Town & Country Planning Act 1990 (as amended)
Town and Country Planning (Development Management Procedure) (England) Order 2015
Application for approval of matters reserved by condition imposed under EP/63/16/PL relating to
conditions 9 for surface water drainage & 10 for SUDs information.
Bradbury Hotel Station Road, East Preston,

Arun District Council have decided to **REFUSE** details reserved by condition for the **following reasons:**

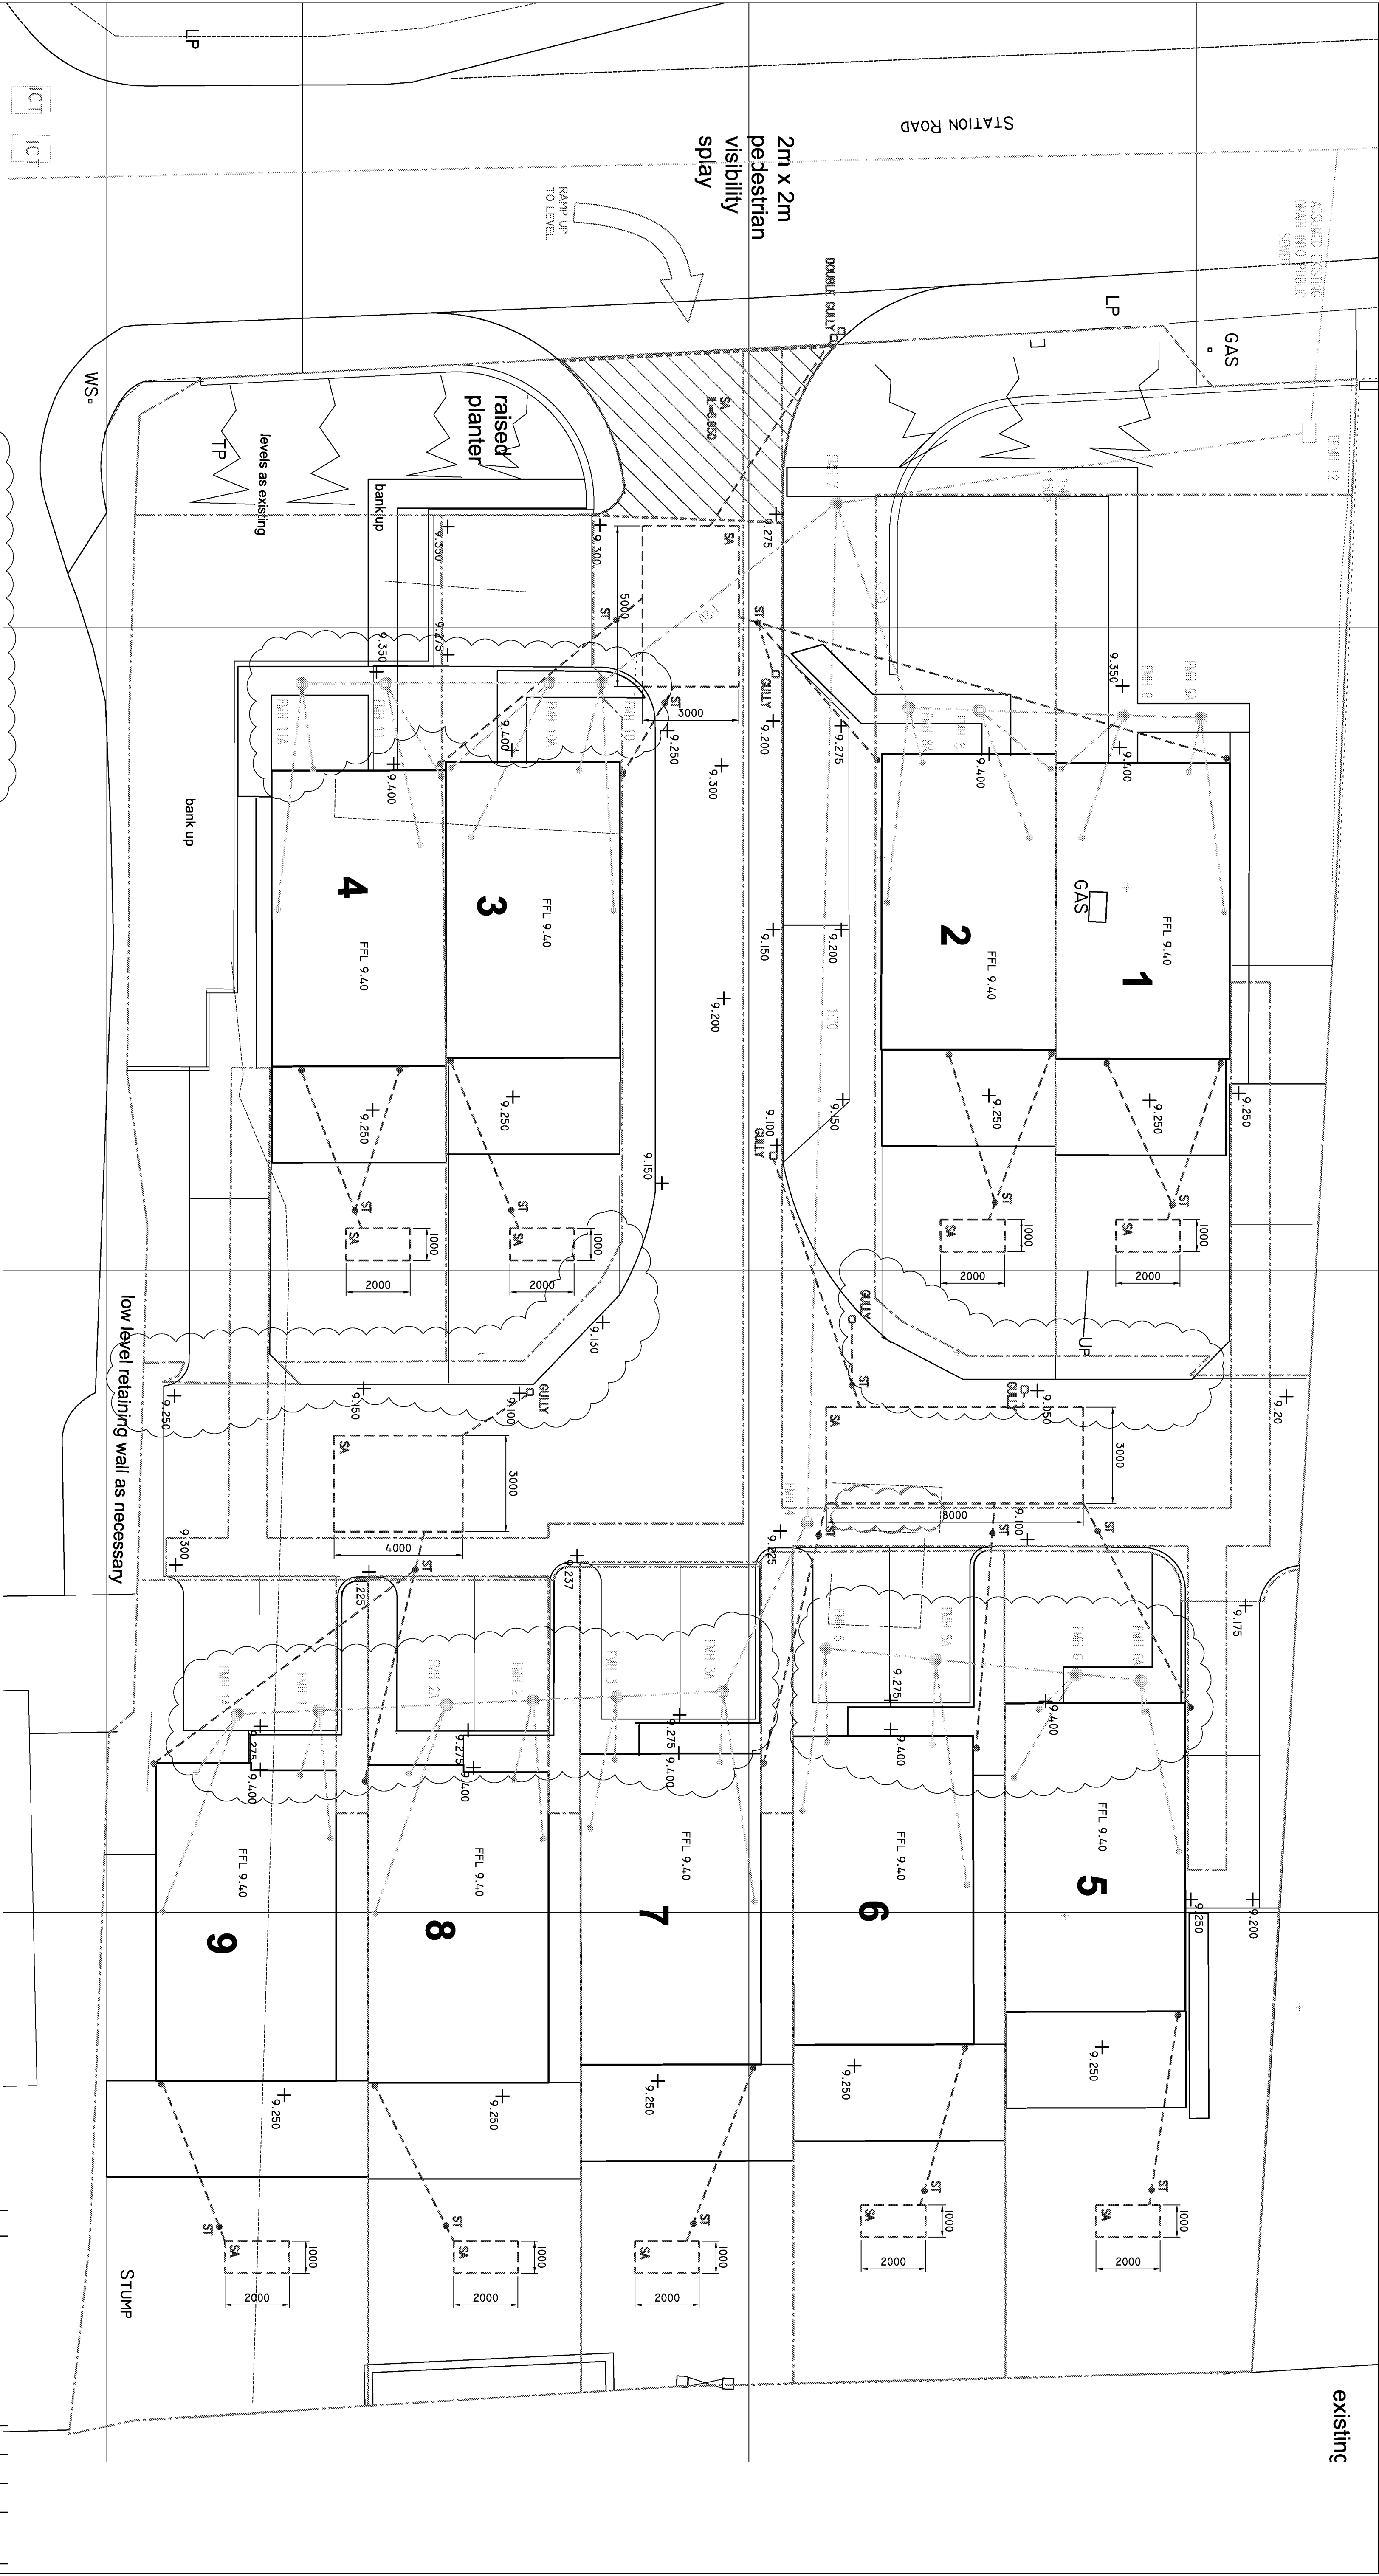
1. Undertake trial hole/s in plots 1 and 2, at location of proposed soakaways, when site conditions allow, to determine depth/existence of the gravel layer.

2. Undertake trial holes in plots 5 to 9 to determine depth/existence of the gravel layer.
3. I await the outcome of items 1 and 2 so the soakaway design can be discussed further.

4. Previous comments to be addressed; Microdrainage calculations - The structures modelled (apart from the 2 x 1m plan area soakaways) do not correspond to the soakaways detailed on drawing WO1371-200 Rev C01, in terms of plan area. The calculations need to be resubmitted accordingly for each different soakaway plan area. This drawing needs to specify the invert levels of the pipe entries into each soakaway, soakaway base and cover levels, top of crate levels. The levels used in the calculations also need to correspond to the relative levels used on the drawing, as currently they do not.

5. Provide silt trap manhole construction detail.
